Fenwick Solar Project Limited

**Planning Act 2008 – Application for a Development Consent Order for Fenwick Solar Farm**

**Applicant Response to Section 51 Advice Letter dated 29 November 2024**

**Application Ref: EN010152**

**PROPOSALS KEY**

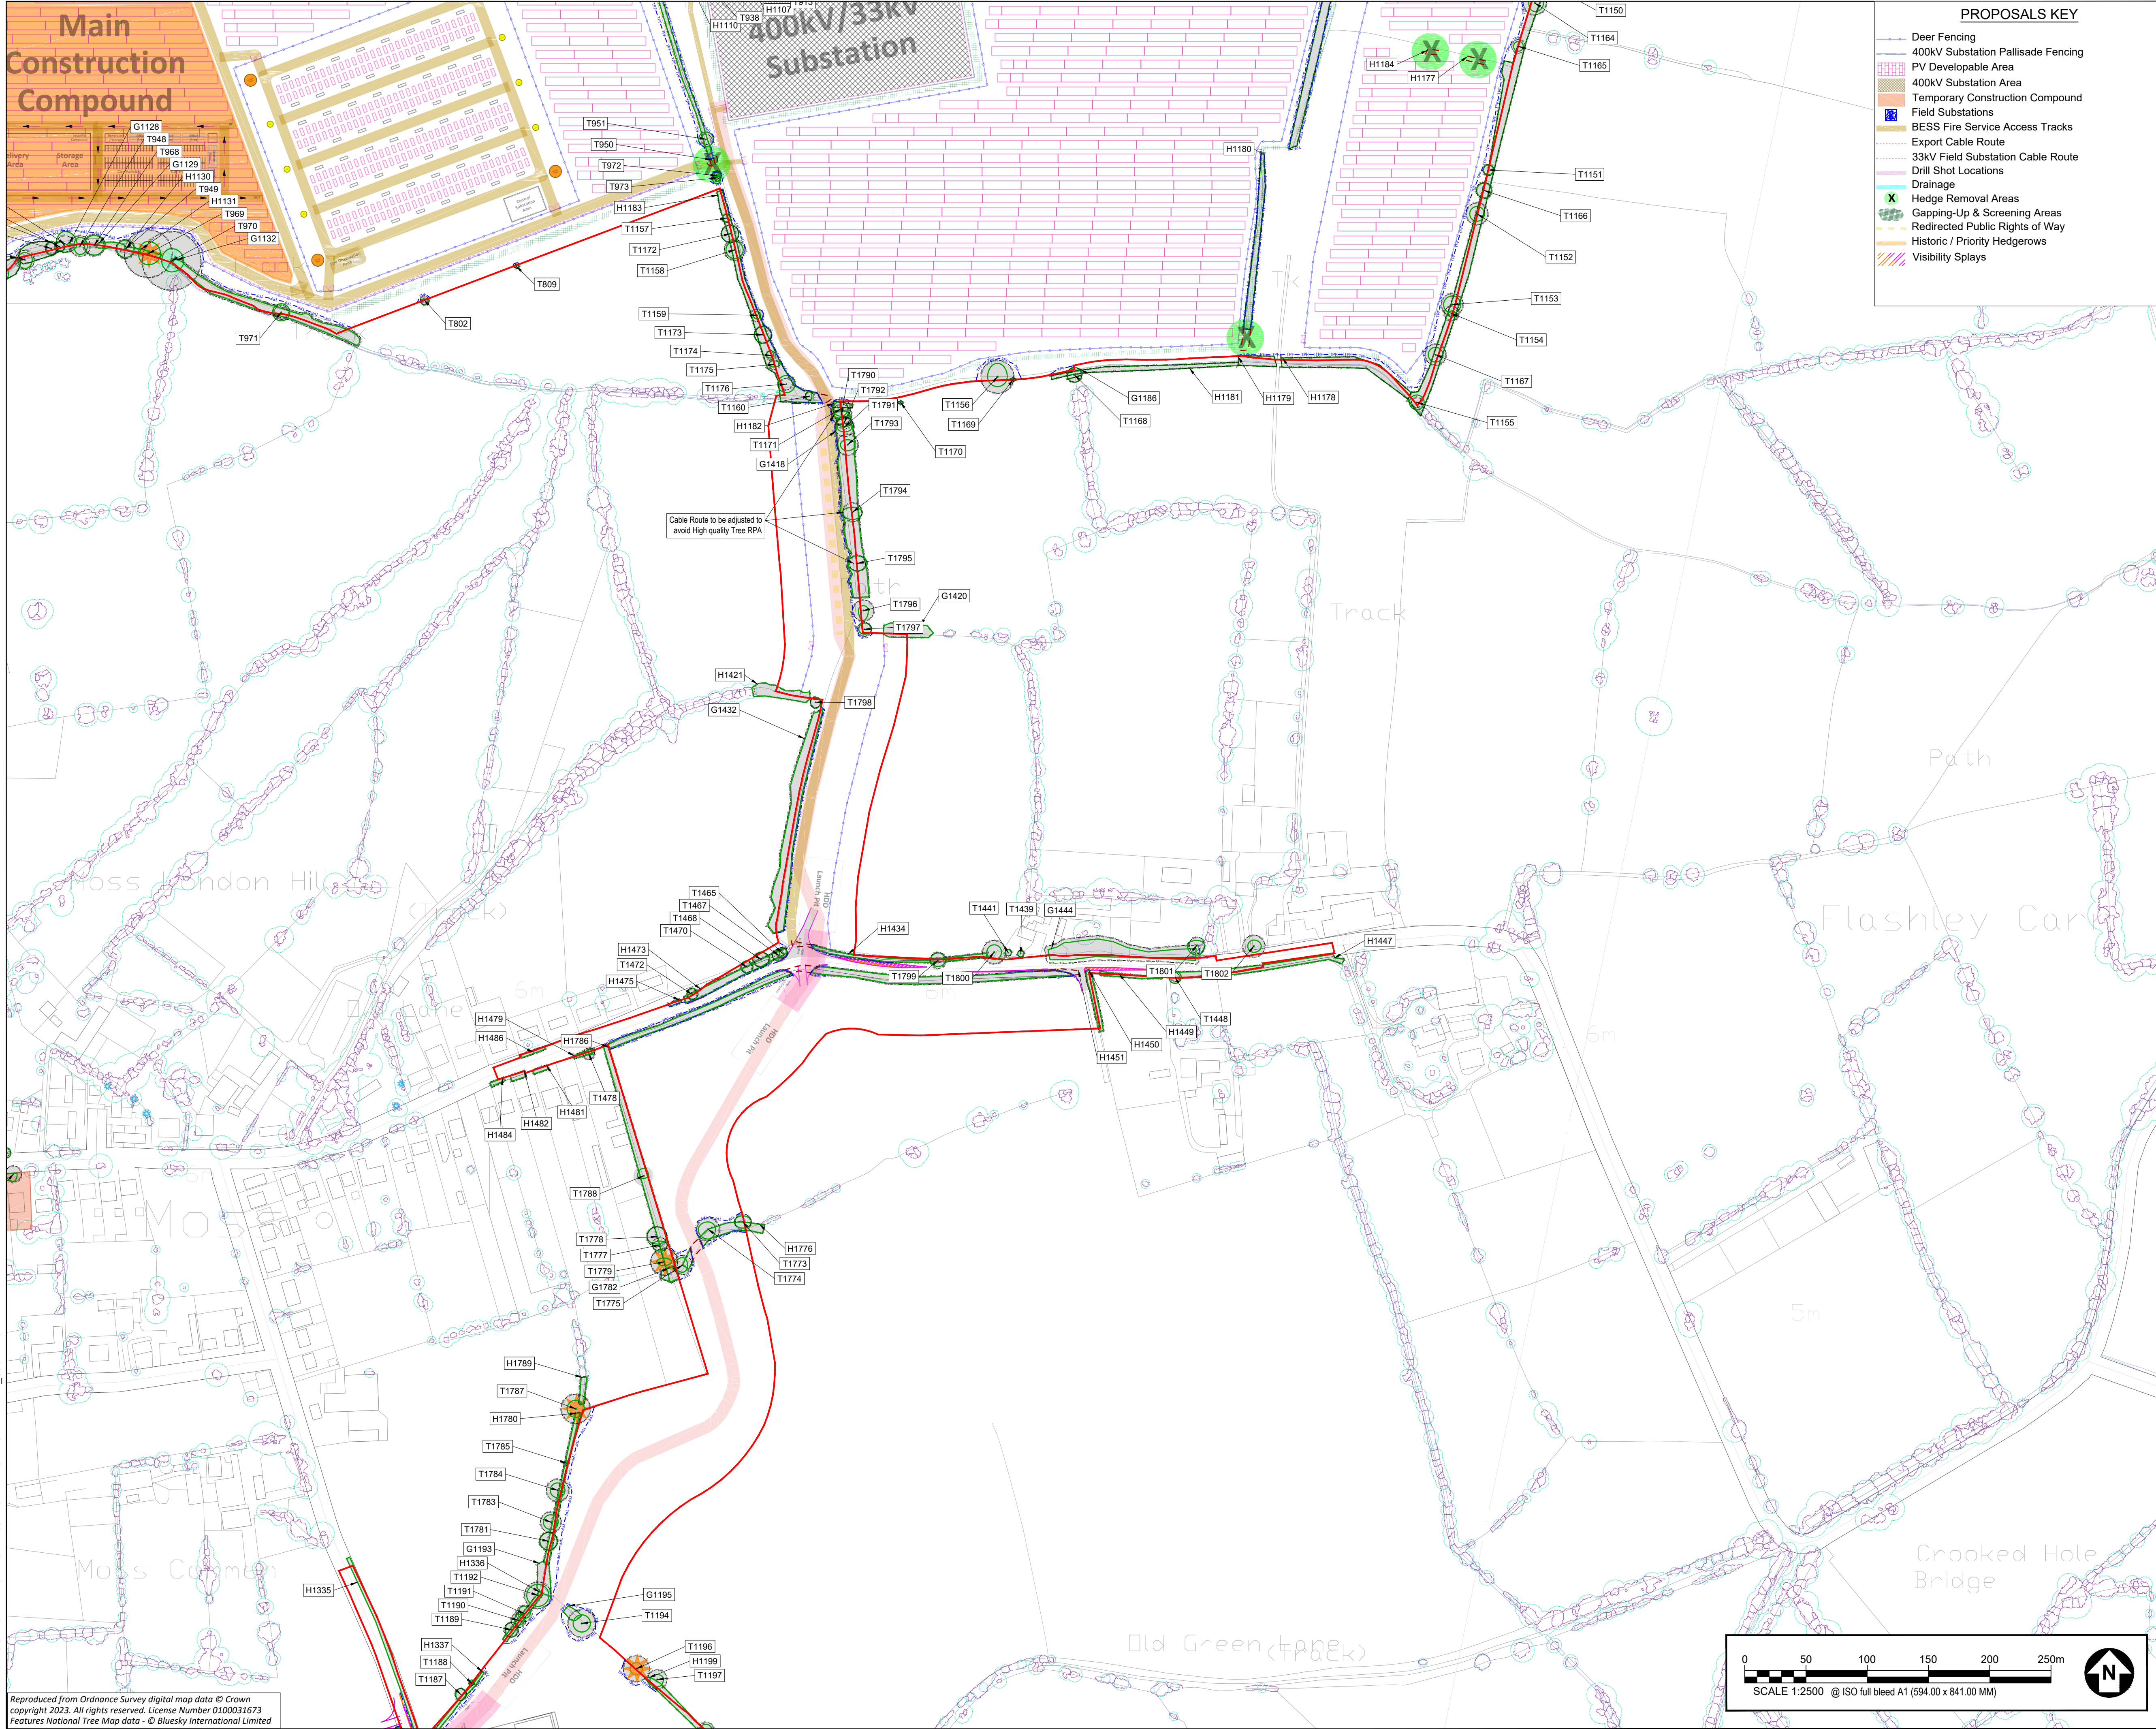
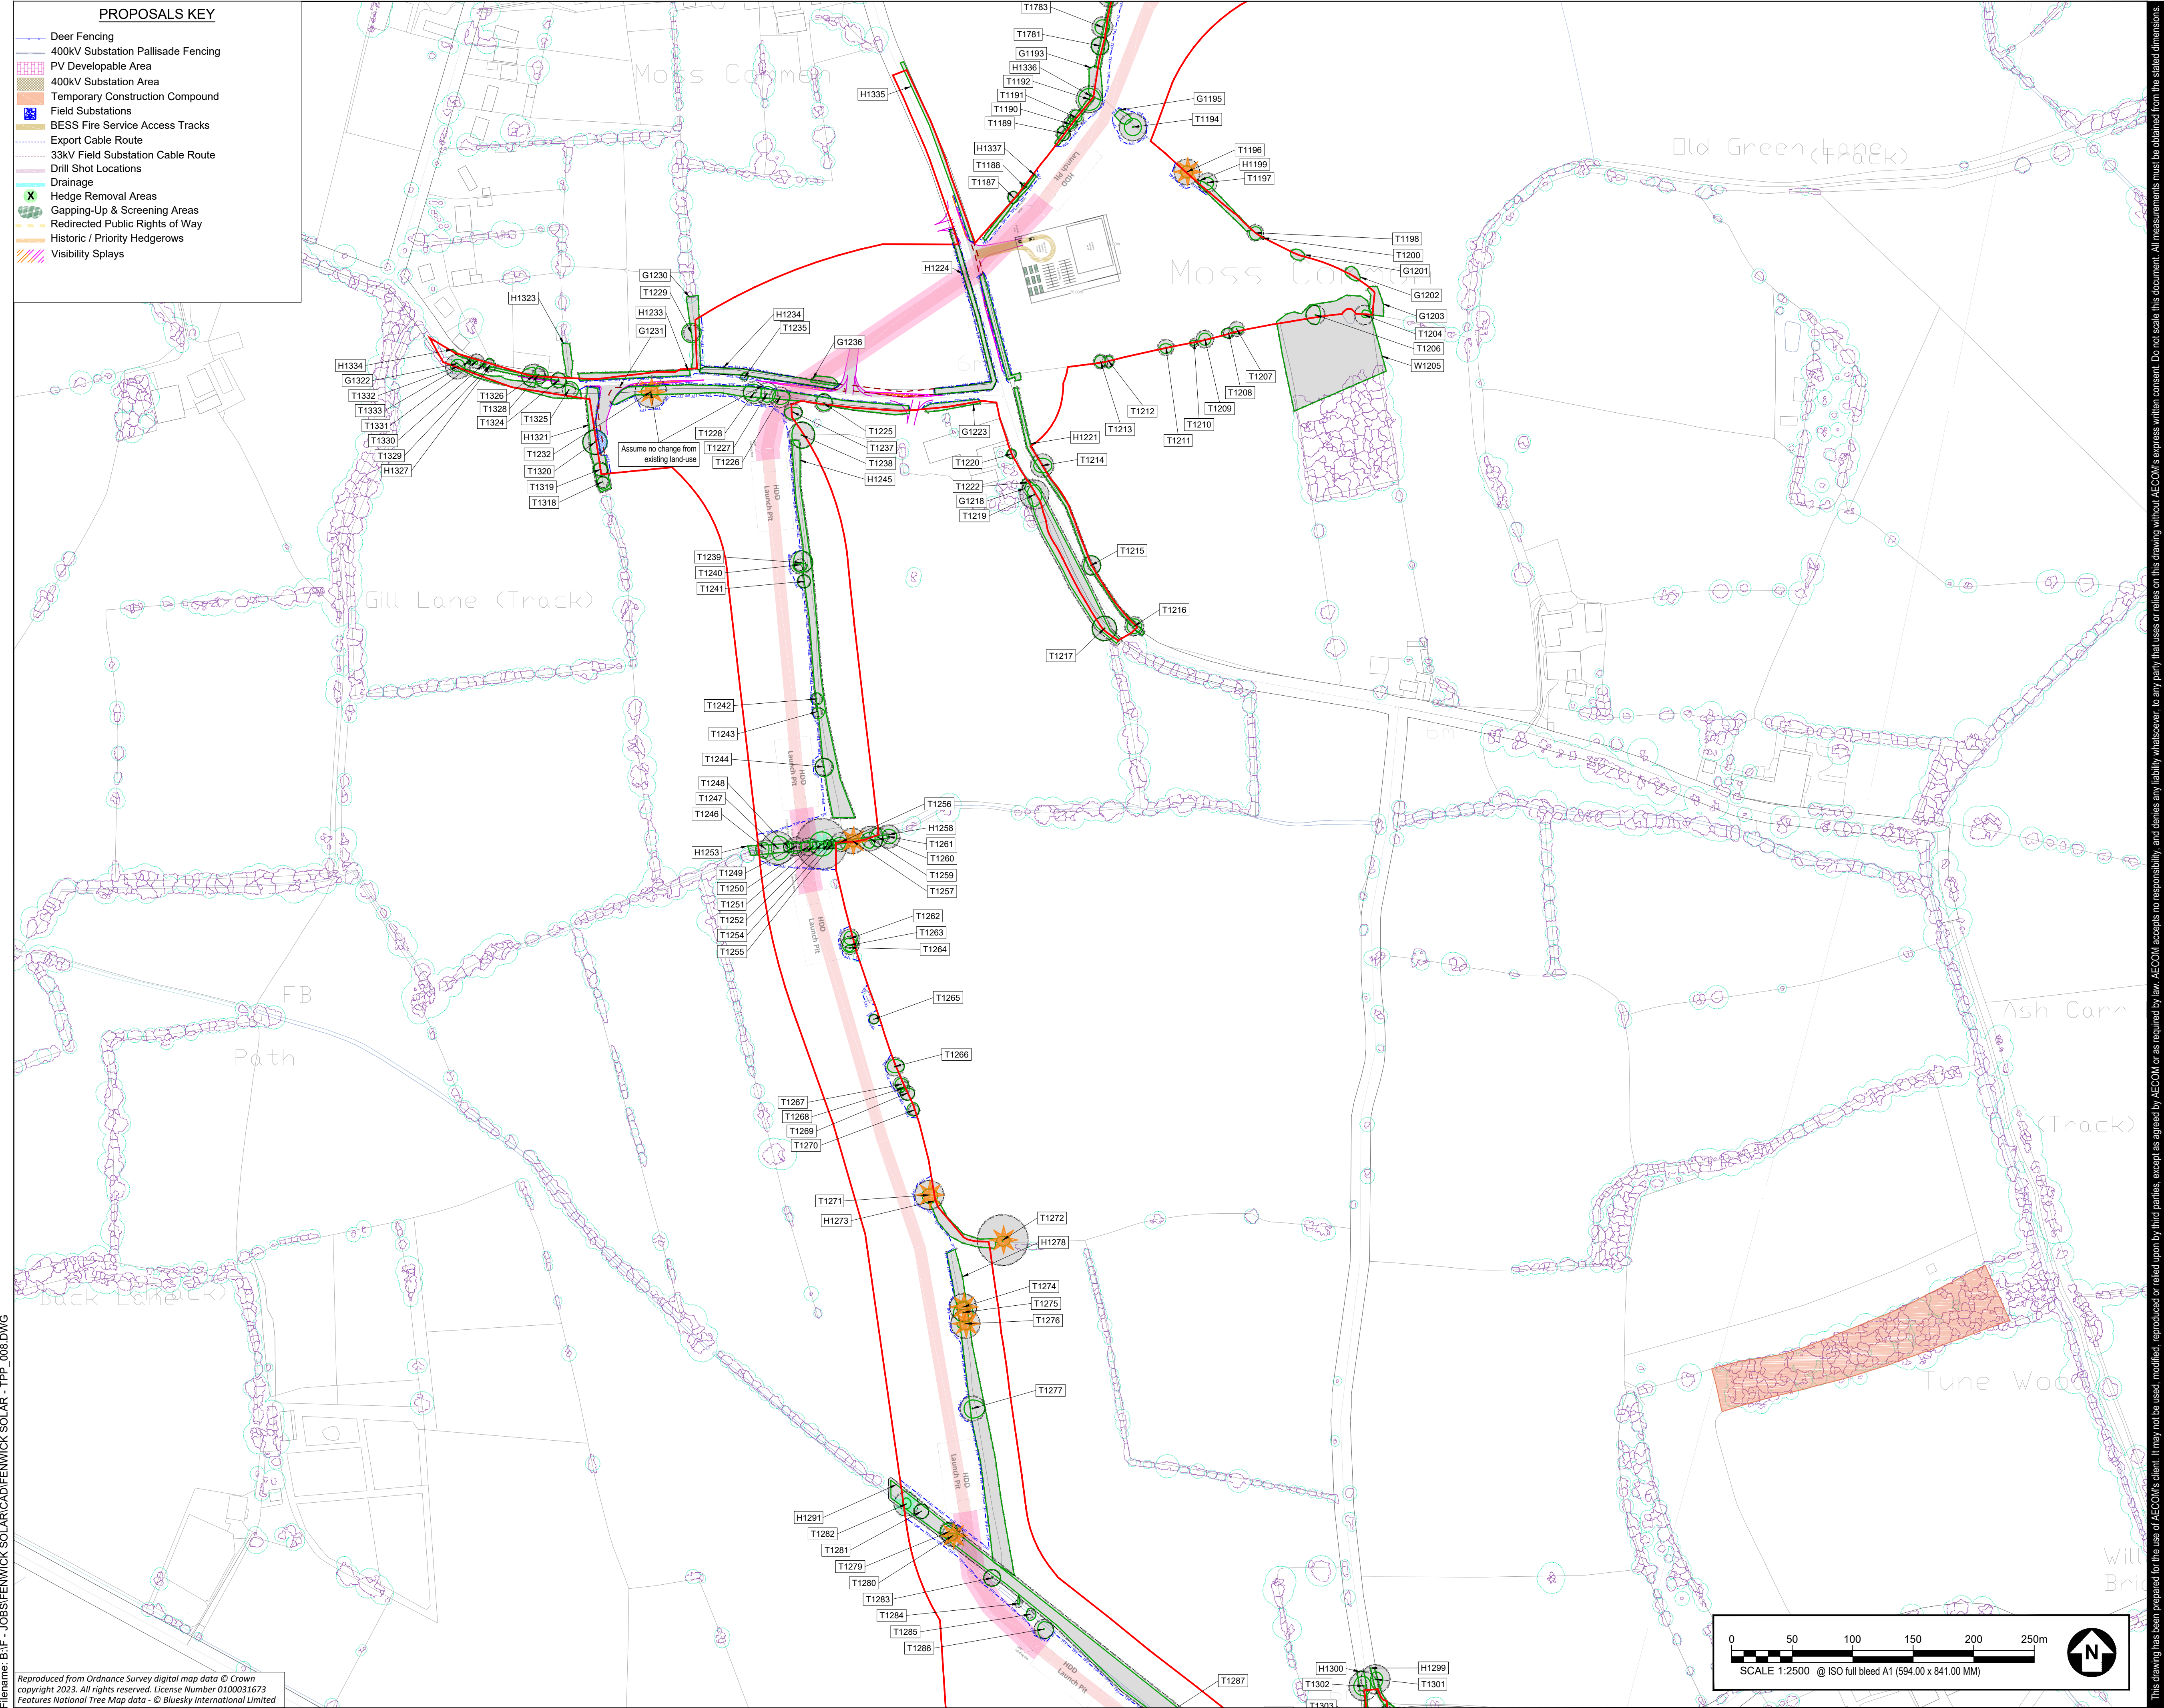
- 1.8.5 **Appendix 10-7: Arboricultural Impact Assessment** (part 1 and part 2) of the Environmental Statement [EN010152/APP/6.3] has been updated by amending the colour scheme of the ancient woodland in both the Tree Constraints Plan and the Tree Protection Plan to provide more contrast between the tree categories and ancient woodland.
